Can you please give East Preston Parish Council 21 days to comment and download plan onto website as a substitute plan.

Further to this morning's meeting at Gladwyn, The Street, East Preston, I can confirm that I am satisfied with the proposed parking provision of 9 spaces as per revised plan provided by Mr Shaw on Friday (11th October).

From: PETER SHAW [REDACTED]
Sent: 11 October 2019 16:39
To: Juan Baeza
Cc: Jamie Brown; Nicola Fry
Subject: Re: Gladwyn - East Preston

Project: Proposed new homes; Gladwyn, The Street, East Preston BN16 1HT			
Drawing: Block plan			
FOR: Mrs. J. Simmonds & Mr. P. Beamish			
Drawn: PKS	Date: November 2018		
Scales: 1:200	No: 2386/01/03/A		
To scale when printed on A3

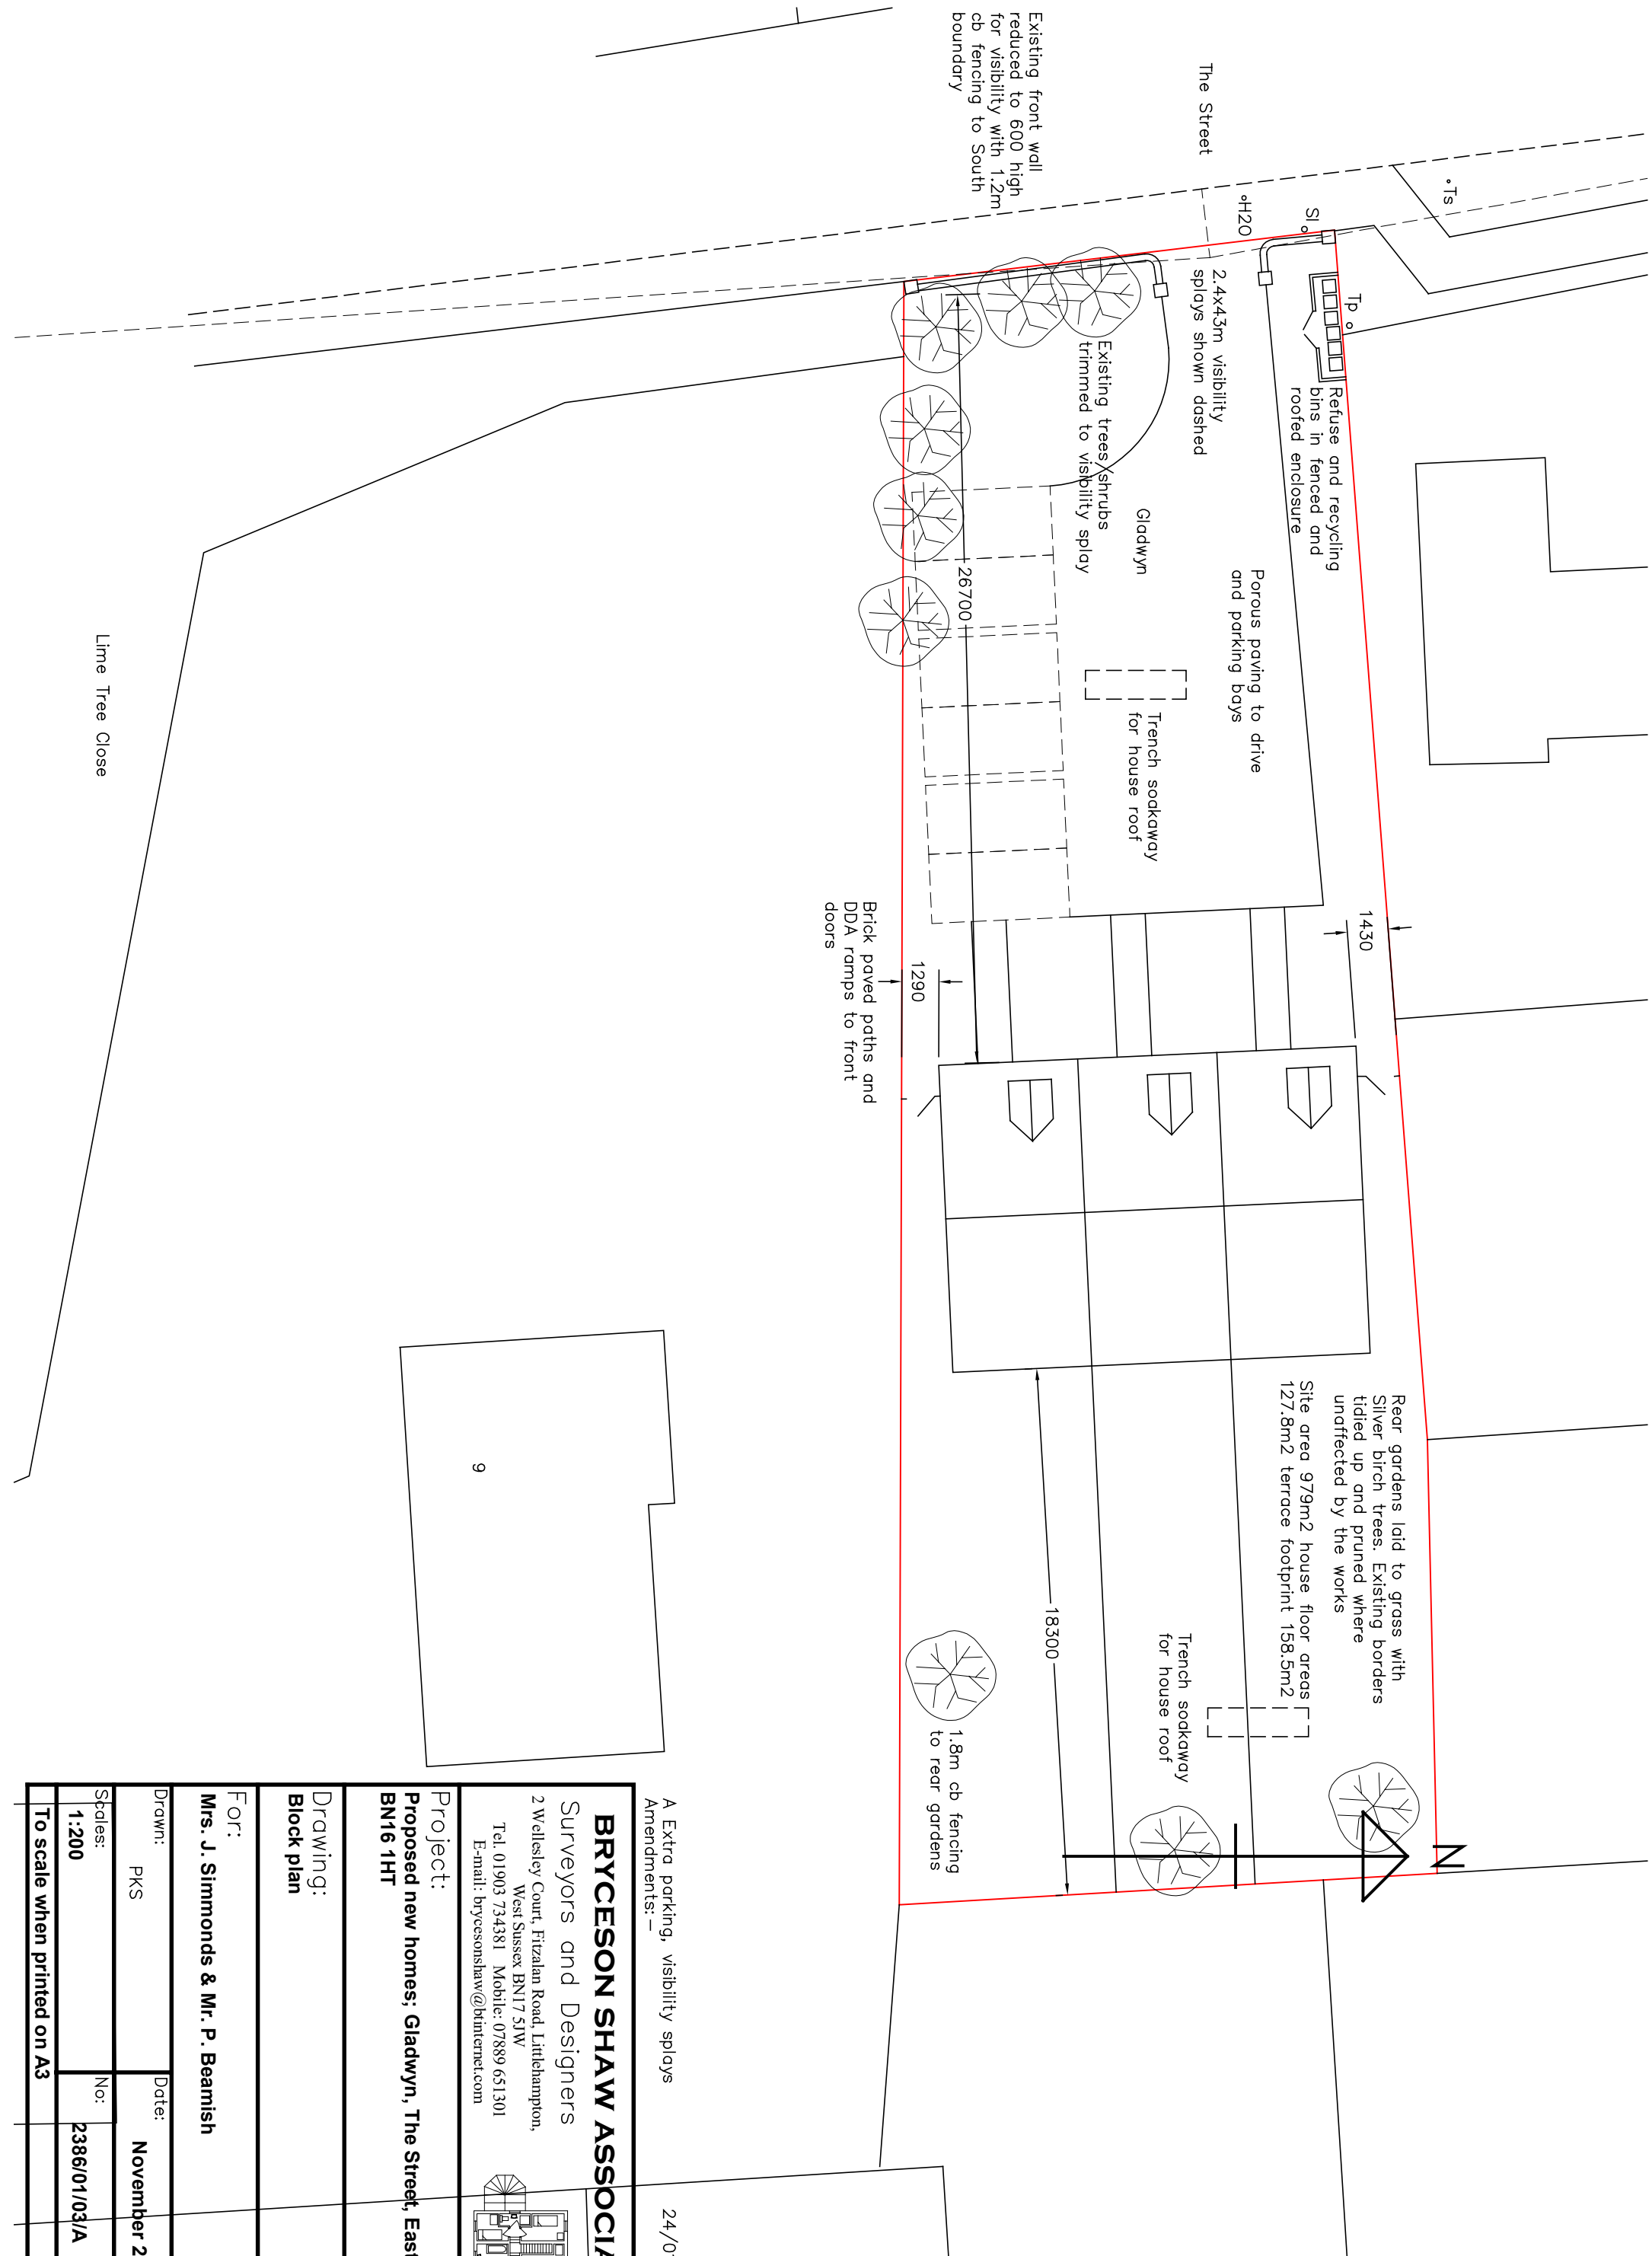
I can confirm that 9 spaces meets the minimum requirements for allocated parking provision, i.e. 2 spaces allocated per dwelling and 3 overspill/visitor parking spaces. I understood from Mr Shaw that he intends to retain unallocated provision, in which case, the proposed provision exceeds the minimum requirement of 7 unallocated spaces.

- The highway officer visiting the site
- Increasing the number of on site car parking spaces
- Providing visibility splays without demolition of front boundary flint wall
- Whether county highway advice was arrived at taking into account appeal decision to allow neighbouring development reference EP/52/18/PL

Project: Proposed new homes; Gladwyn, The Street, East Preston BN16 1HT			
Drawing: Block plan, bin store elevations			
For: Mrs. J. Simmonds & Mr. P. Beamish			
Drawn: PKS		Date: November 2018	
Scales: 1:50 1:200		No: 2386/01/03/C	
To scale when printed on A3

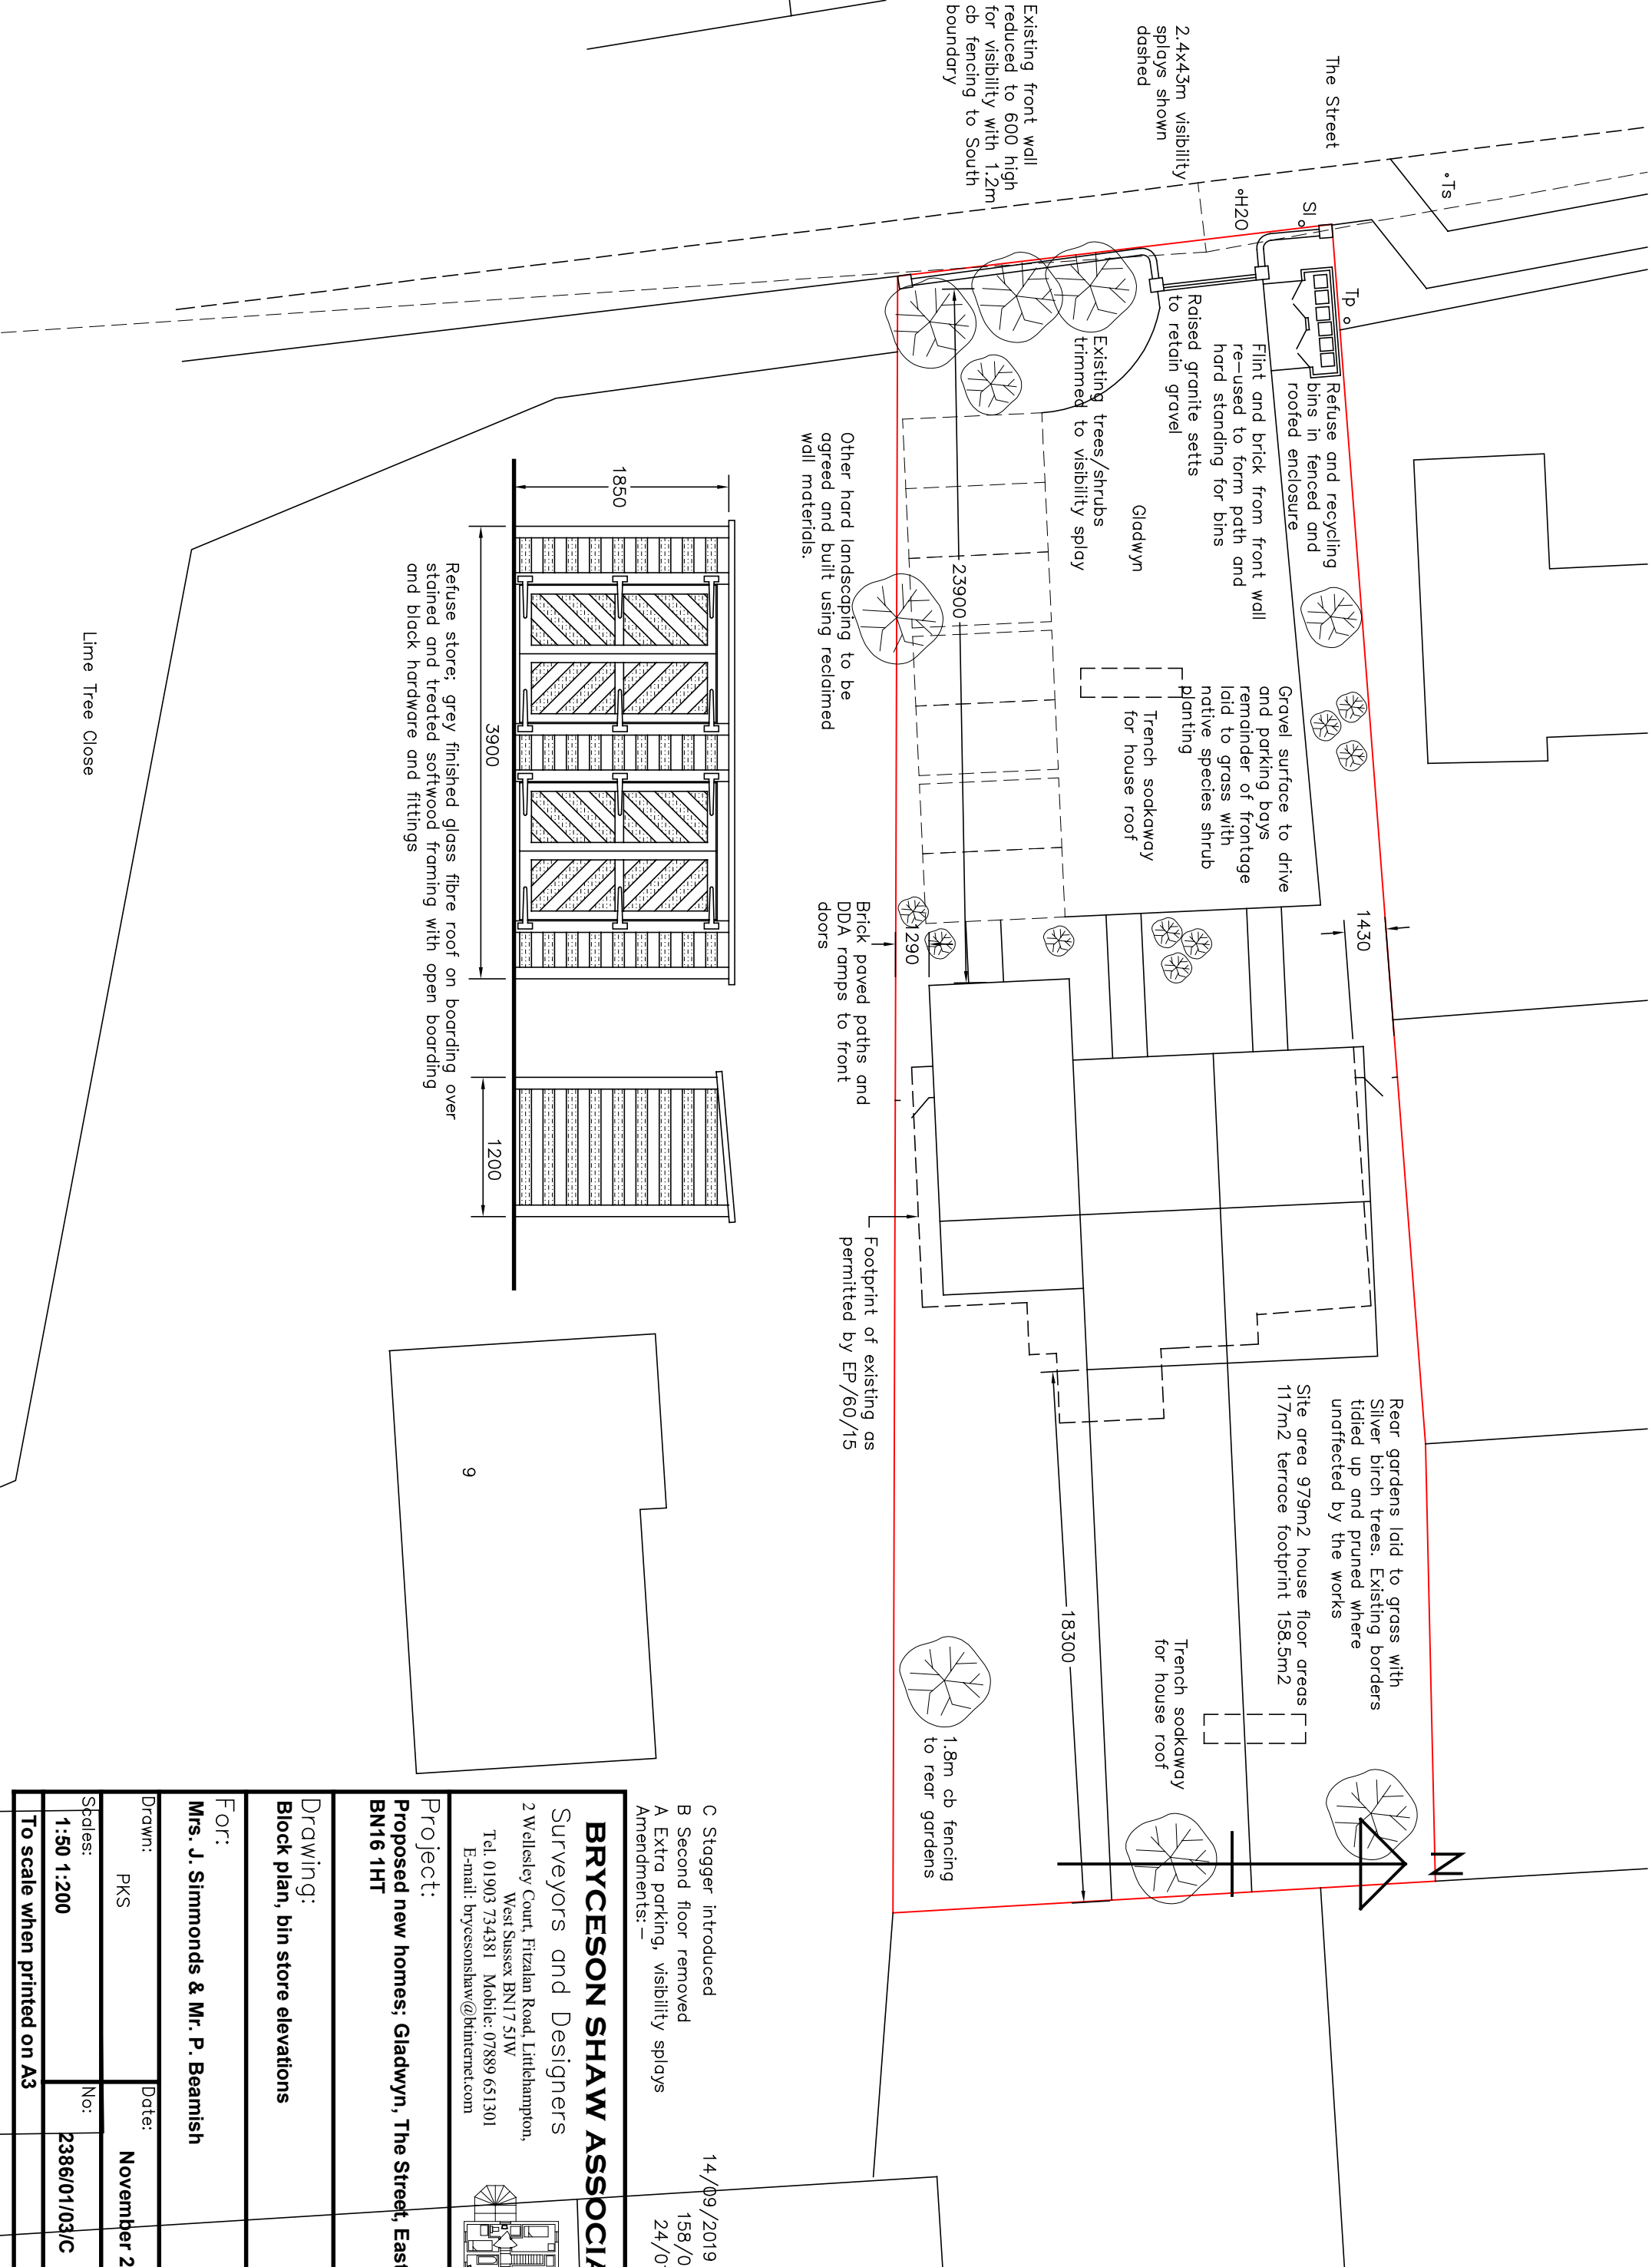
With regards to the boundary wall, we measured visibility on site at a distance of 2.4m back from the carriageway edge. In the leading direction (to the north of the access) 43m visibility is achievable in accordance with Manual for Streets (MfS) standards, without any alterations to the existing wall required. In the trailing direction (to the south), visibility is obstructed by the wall and overgrown hedges.

The current height of the boundary wall is 1.2m. We discussed two options on site, firstly the reduction in height of the wall, and secondly relocating the wall within the site. In its current position, due to the proximity to the school, we would require the wall to be reduced in height to 600mm to allow visibility of small children. However, we did agree on site that a compromise could be reached and we would support the wall being reduced in height to 800mm. This option would still result in some loss of the wall. We then discussed the option of repositioning the wall to a set-back of 0.5m from its current position. It was agreed by all that this would be the favoured option as it is anticipated to provide a full unobstructed visibility splay of 43m to the south and would not result in any loss of the flint wall.

Subject to a revised plan confirming that a 0.5m set-back would provide the required 43m splay to the south, I would not consider that this proposal would have an unacceptable impact on highway safety or result in 'severe' cumulative impacts on the operation of the highway network, therefore is not contrary to the National Planning Policy Framework (paragraph 109), and that there are no transport grounds to resist the proposal.

As discussed on site, I would request that a condition securing visibility splays (details to be provided) is applied.

Thank you for the meeting today and for your help. Please see the attached revised drawing showing the garden wall rebuilt some 500mm into the garden.

I would like to retain the Southern most brick pier as it defines the 2 boundaries of the plot and should not affect visibility. The final decision on this can be made once we start site clearance and can properly set things out.

I have plotted the drawing on A2 paper so the extent of the visibility splays is clear.
